DE-2025/112

06 November 2025

Development	State Significant Development (SSD-76440958) – South House – Mixed Use Development with Infill Affordable Housing (WIN Grand) – Request to Provide Advice on the Environmental Impact Statement (EIS), the Proposal and Recommended Conditions
Location	Lot 4 DP 17979, Lot 5 DP 17979, and 1 more, Lot 1 DP 112417, Lot 100 DP 774957, Lot 9 DP 551157, Lot 8 DP 546125, Lot 1 DP 220513, Lot 2 DP 17979, Lot 3 DP 17979, Lot 1 DP 17979, Lot 7 DP 878243, Lot 1 DP 1135333, Lot 1 DP 183348, Lot 1 DP 226374, and 1 more, Lot 1 DP 82673, Lot 1 DP 117019, Lot 1 DP 302824, Pt Lot 1 DP 927806 Lot 1 DP 1087986 WIN Grand - Burelli, Crown & Kiera Streets WOLLONGONG NSW 2500

Project Title: 221-291 Crown Street, 216-238 Keira Street, 86-90 Burelli Street, Wollongong NSW 2520. Drawing Title: GENERAL ARRANGEMENT PLAN SHEET 02. Drawing No: S02-C302. Date: 24.04.25. Issue: 01. Project Manager: [Name]. Design Engineer: [Name]. Checker: [Name]. Approver: [Name].

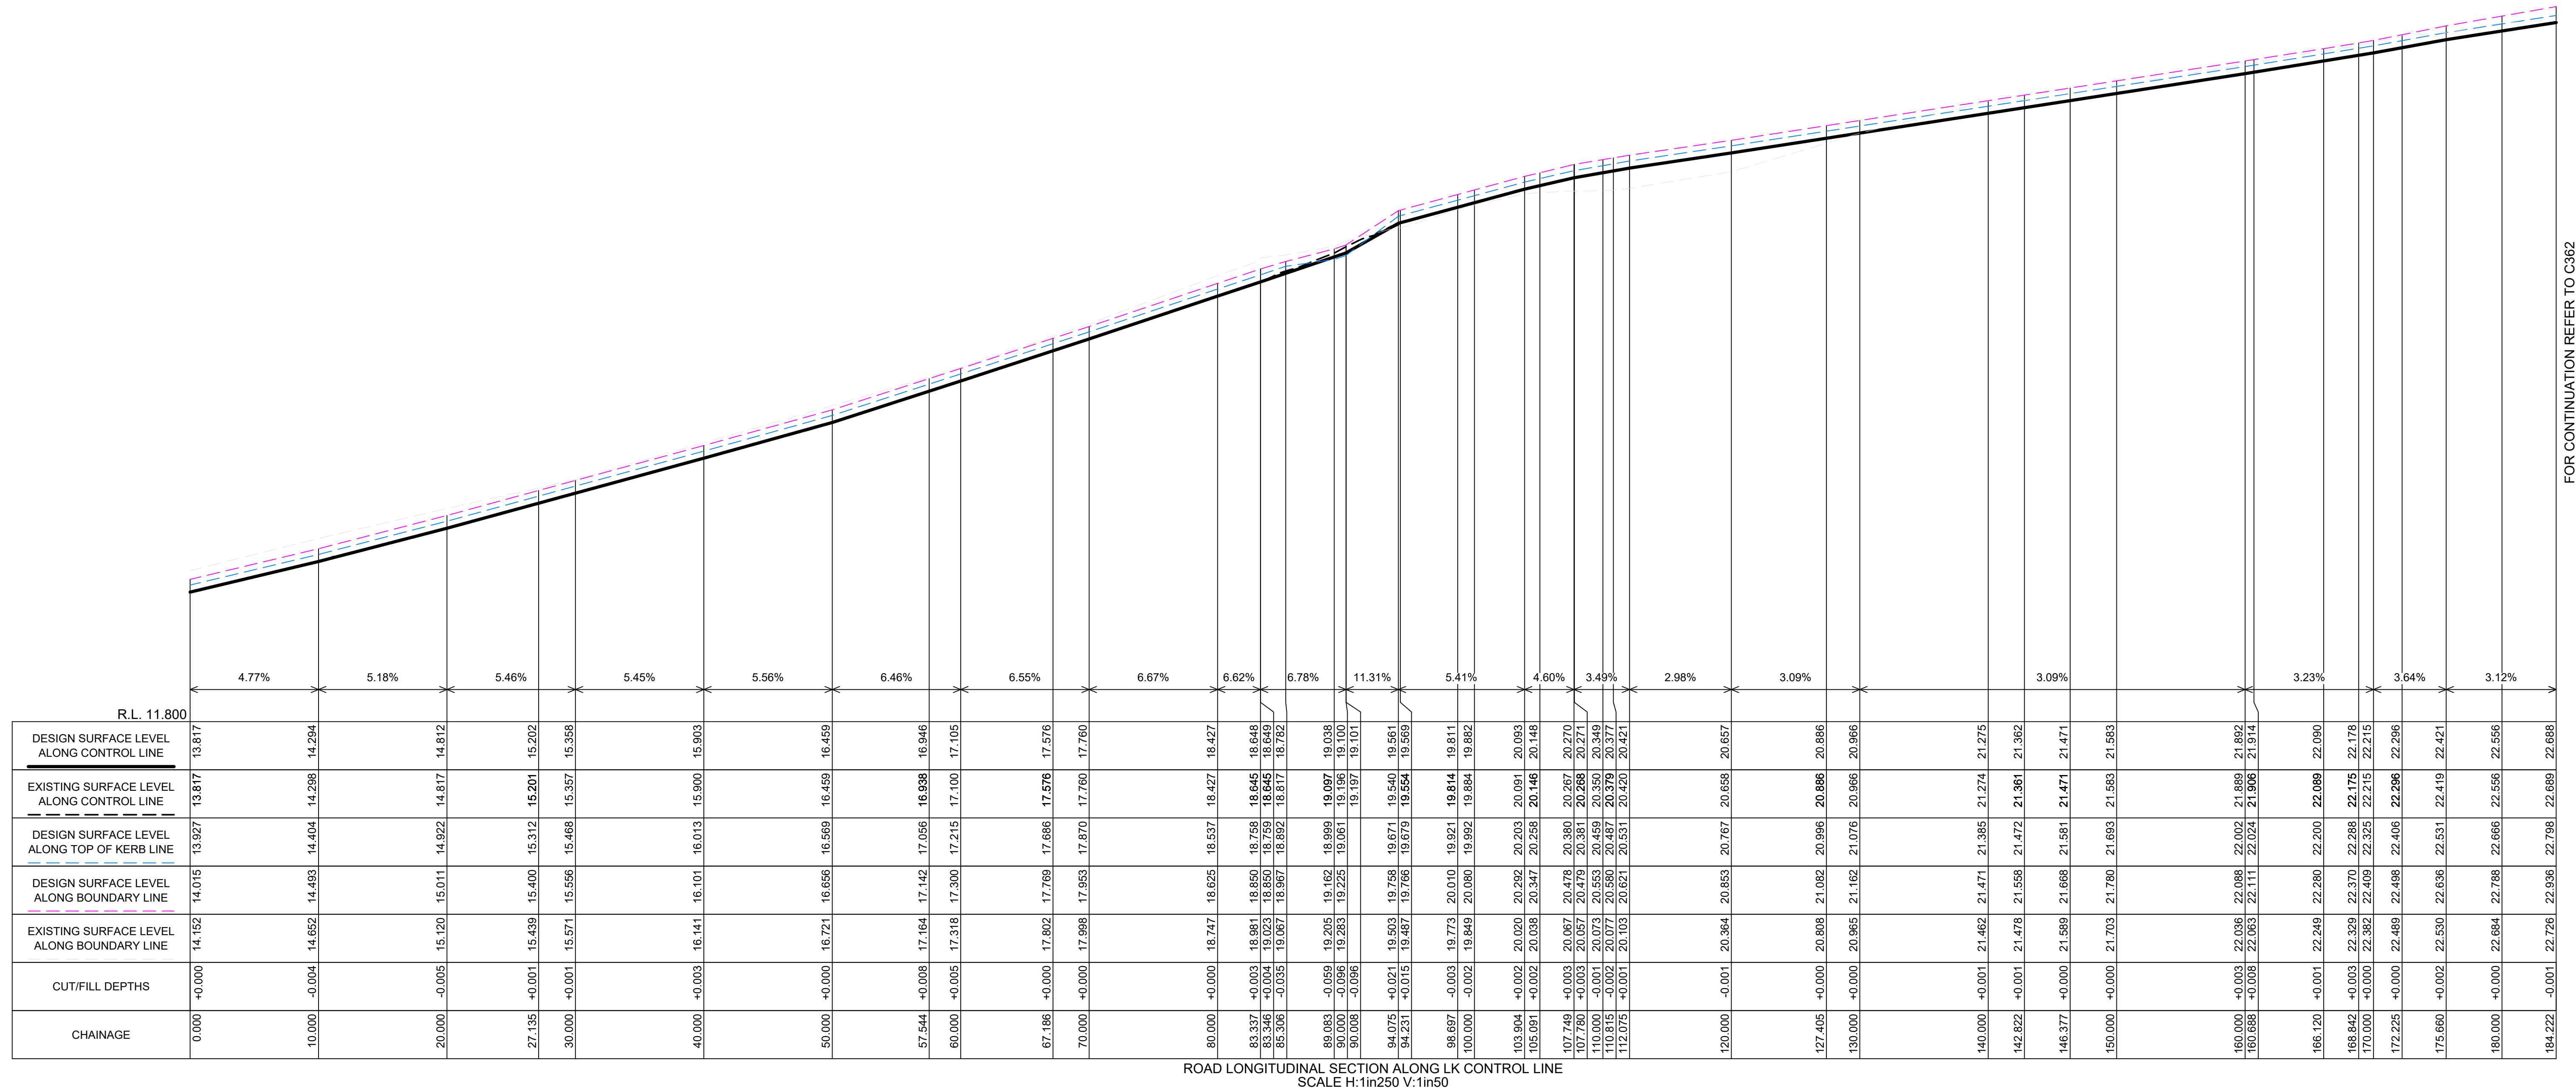
- 4(b), 4(e)(x) and 4(e)(xi): the following concerns are raised regarding the public domain:
 - Under DA-2021/957, extensive work was done to establish the desired footpath levels and widths along with kerb alignments for the perimeter of the block. Those design drawings involved lengthy consultation with relevant stakeholders within Council and Transport for NSW should be maintained under the current proposal as they are essential to achieving necessary pedestrian amenity, incorporate bus stops, taxi zones and the like. The detailed design drawings have been previously provided to the proponent and the sDRP.

- Detailed sections and elevations from kerb to building entries are required that reflect these design drawings for the full frontage of the development.
